This Representation from Kent Ramblers follows our earlier written comments and an overview I gave in the Open Meeting on 19<sup>th</sup> November. As a volunteer Local Footpath Officer, responsible for responding to Planning Applications in a number of parishes, including Aldington. I have attended the Community Liaison panel since 2022 and have visited displays in Mersham, Sellindge and Bilsington.

## **Consultation on the PROW network**

## **Proposed PROW routes**

STONESTREET GREEN SOLAR
STREETS, RIGHTS OF WAY
AND ACCESS PLANS
142-02-71 REV. 01
SHEET 3 OF 10
APPF Regulation 5(2)(k)

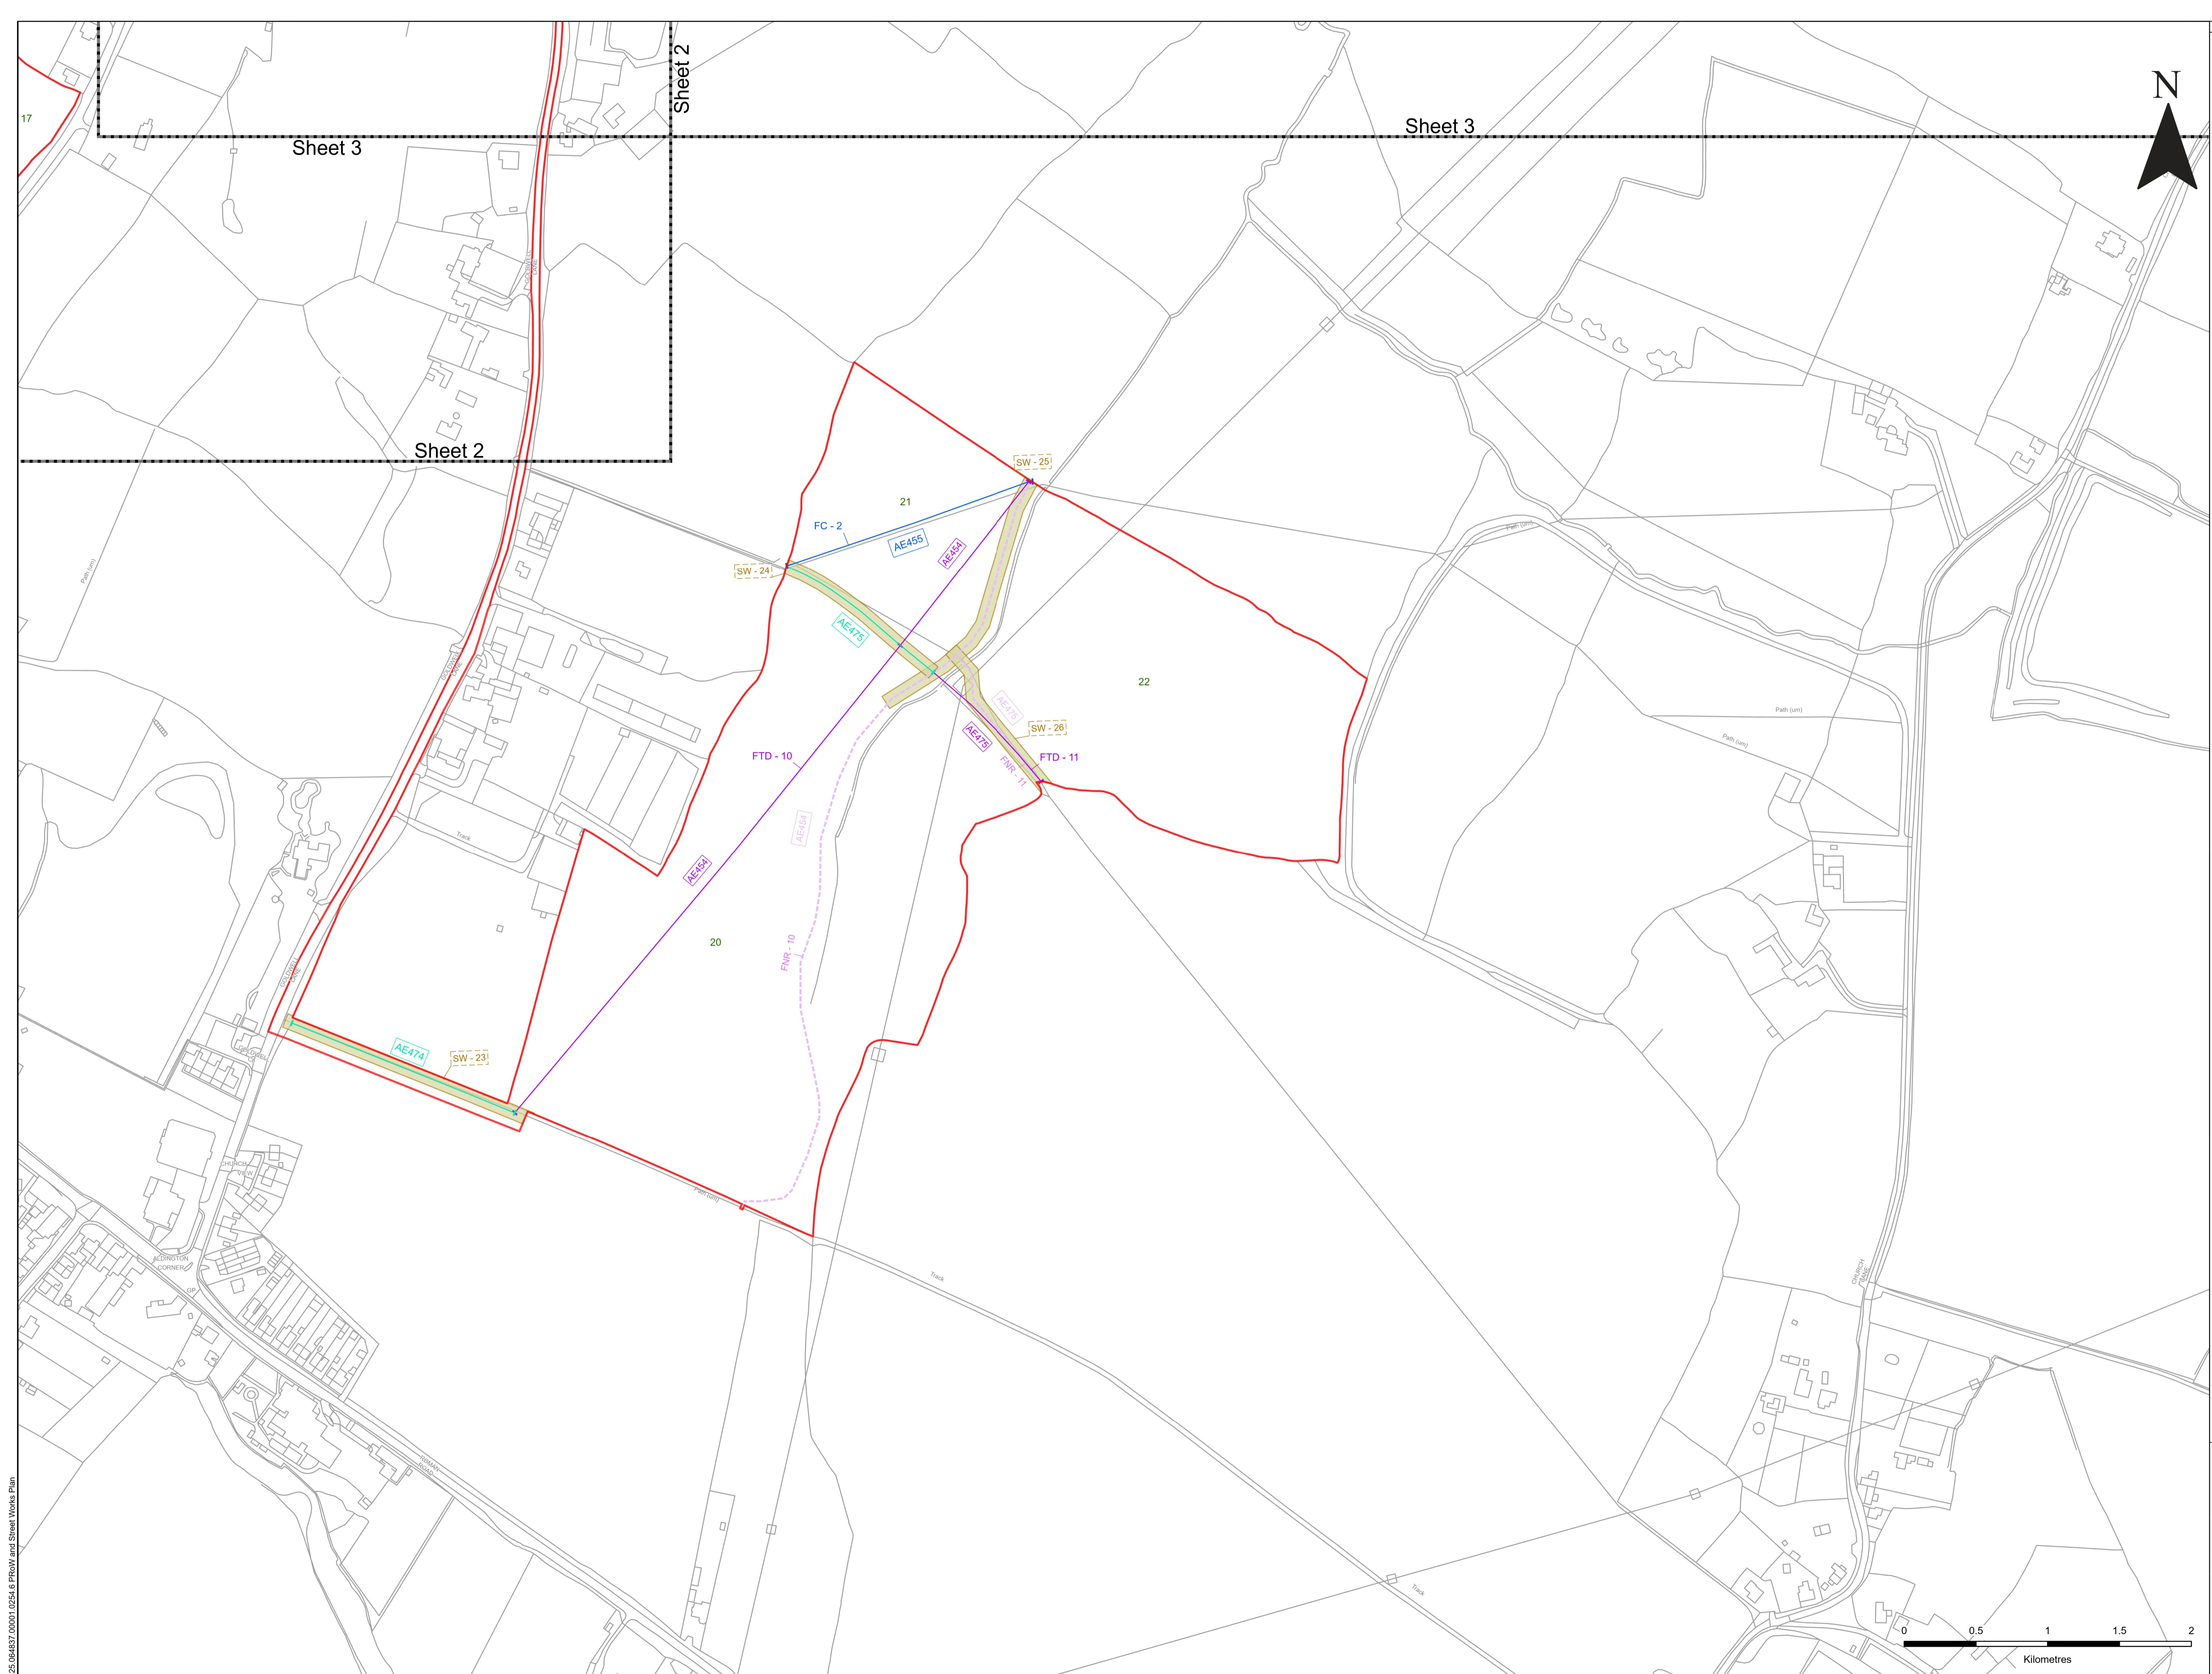
**454** We are concerned about and do not support the proposal to move the line of **454** from the crest of the field down into the valley, next to a ditch, which will decrease the enjoyment of walkers and may create a boggy surface. We suggested moving this path west to the edge of the field and understood this would have been a likely diversion but there were "issues". Some exploration of this may shed light and explain why panels can be placed here but a PROW cannot. This path which links with the very well used **474** should remain where it is. Conditions should be applied to ensure that **474** stays clear of obstructions during construction.

**475** We note this minor diversion of a short section, near a pylon.

**455** We note the extinguishment of this very short short cut.
